2 May 2013

DeskSite ref: 2440873

**RE: Project Application for a Mixed Use Development  
Former Allied Mills Site, 2-32 Smith Street, Summer Hill (MP 10\_0180)**

TfNSW has reviewed the proposed development and provides the following comments:

Drawing
DA-1002
SITE THROUGH LINK
SITE 2

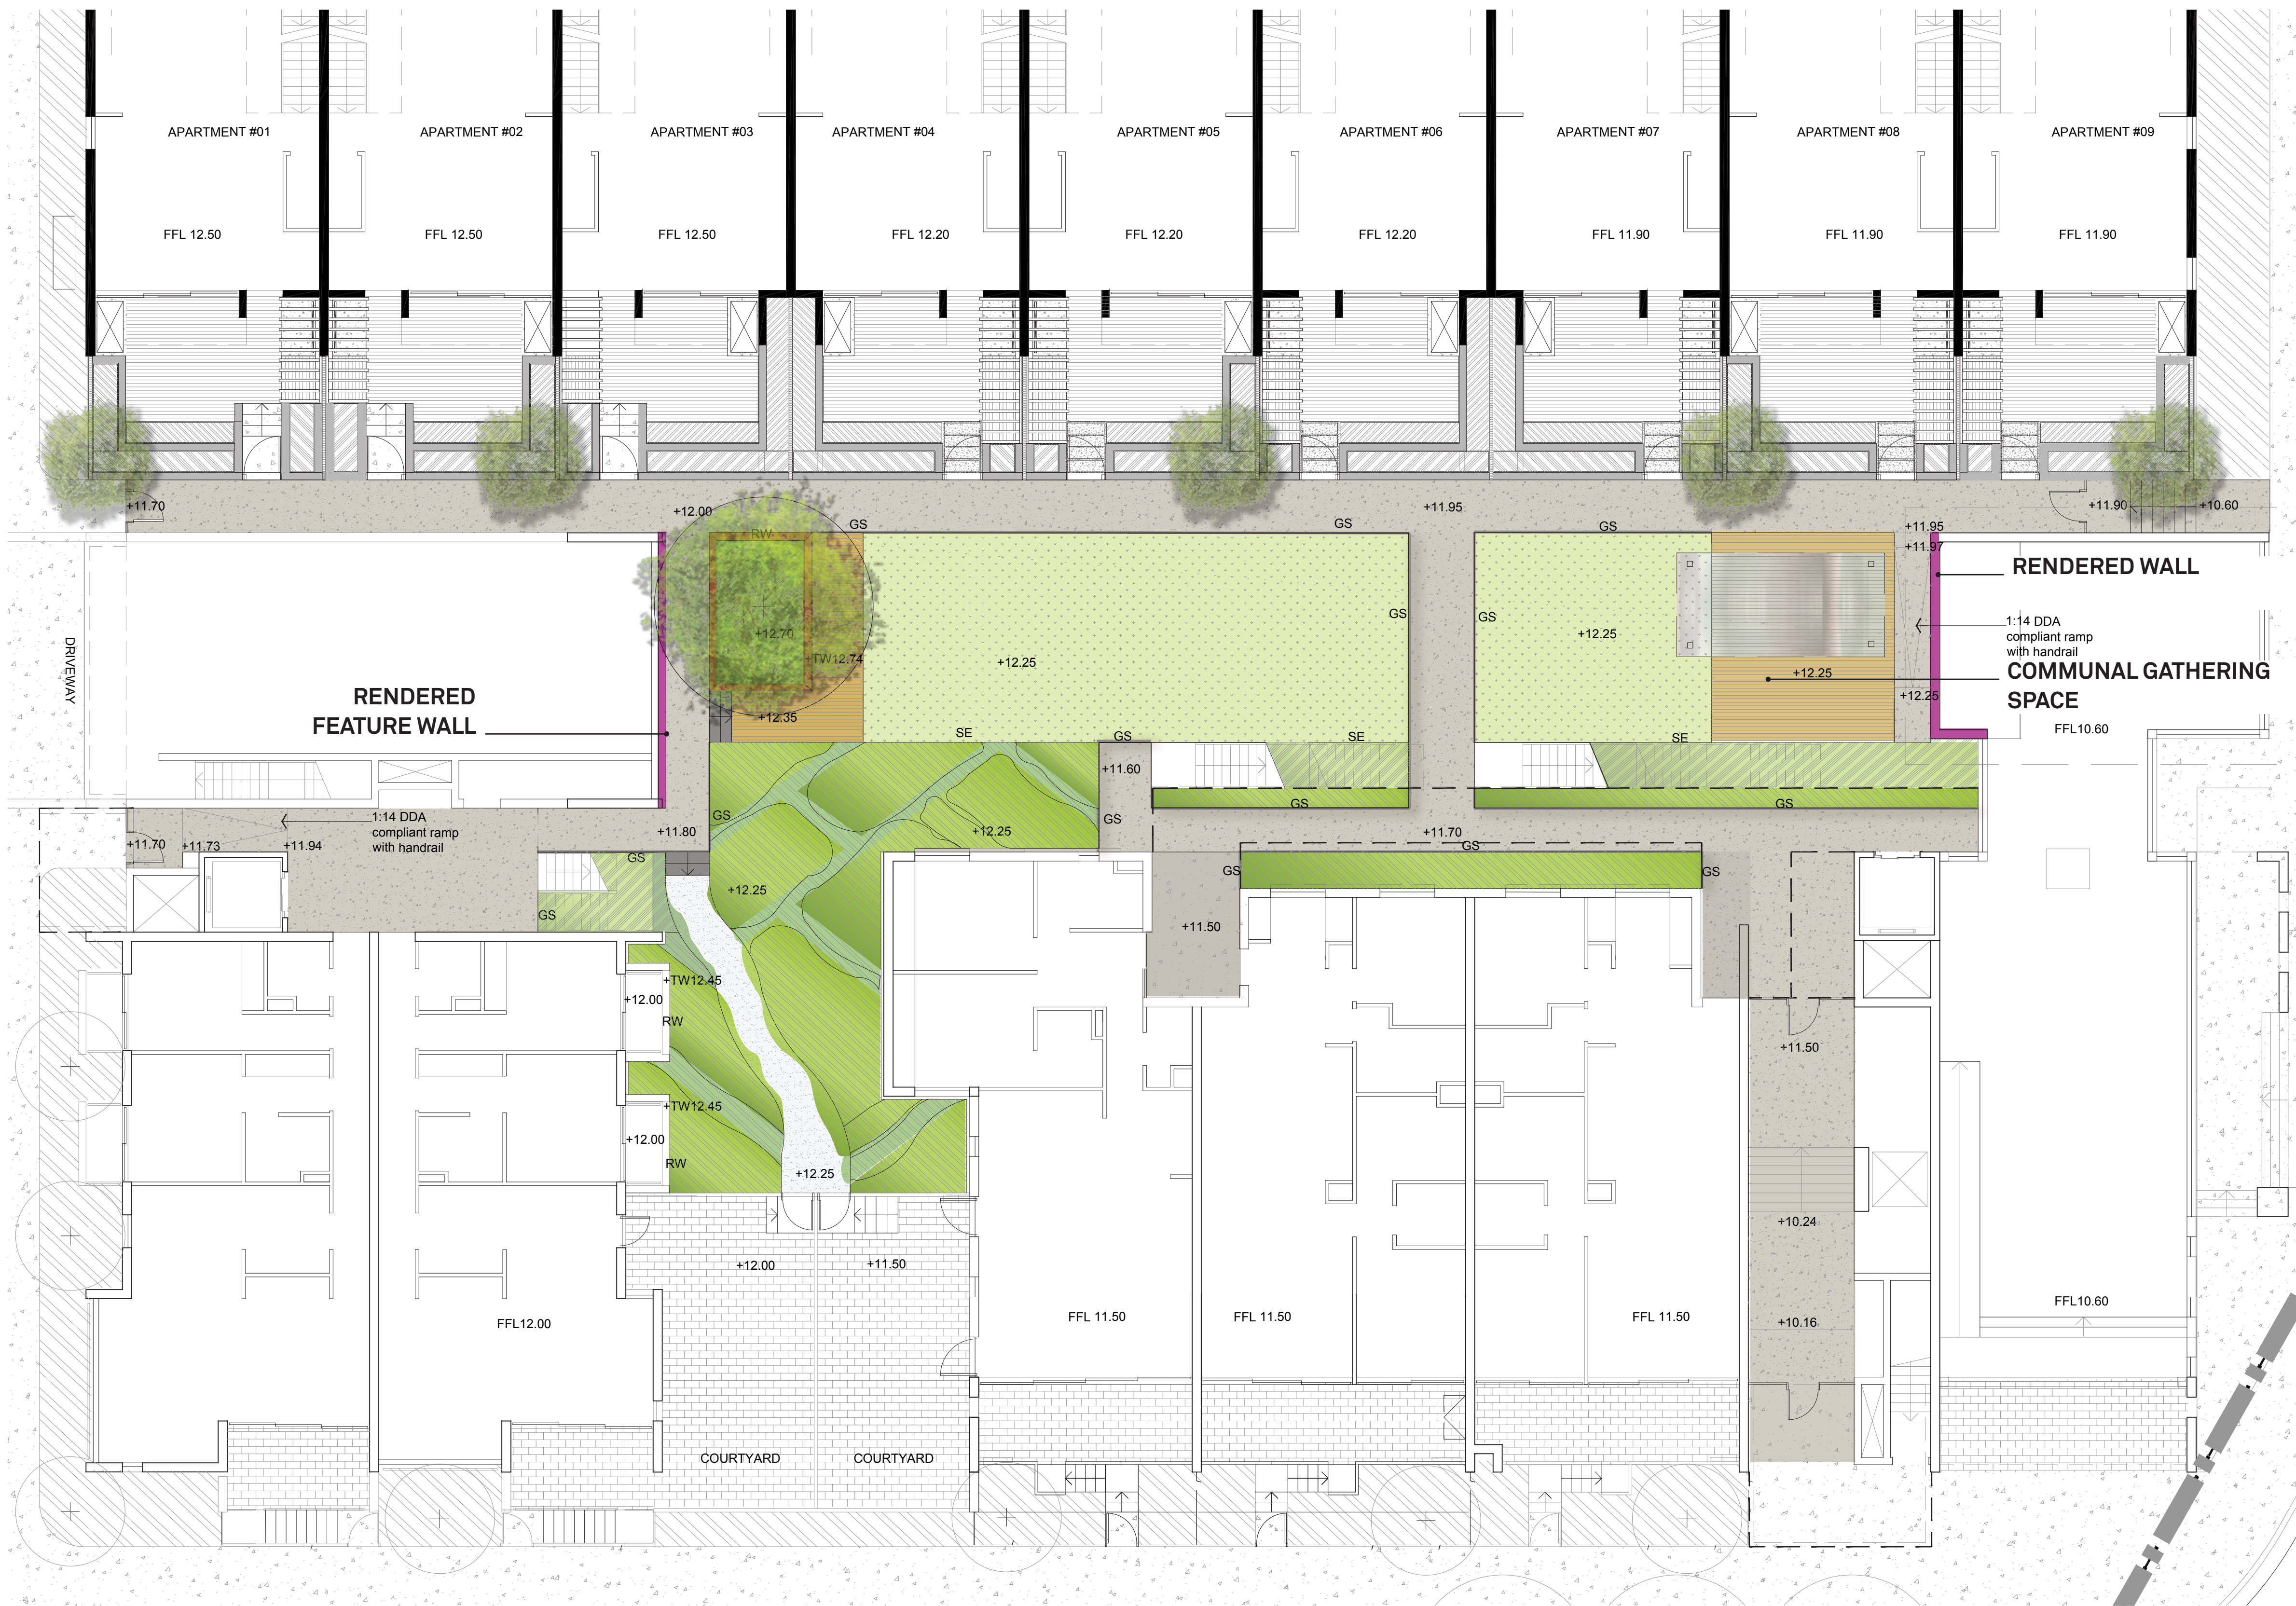
1. The proposed through site link from the light rail stop (shown to have a nominal width of 3m) to the new road connections with Edward and Smith Streets should be designed to cater for all users, including those with disabilities, and provide for good public pedestrian / cyclist permeability through the development. It is not clear whether the access in the vicinity of the commercial/ retail Building 1C with the level changes shown is accessible (in accordance with the required access standards).
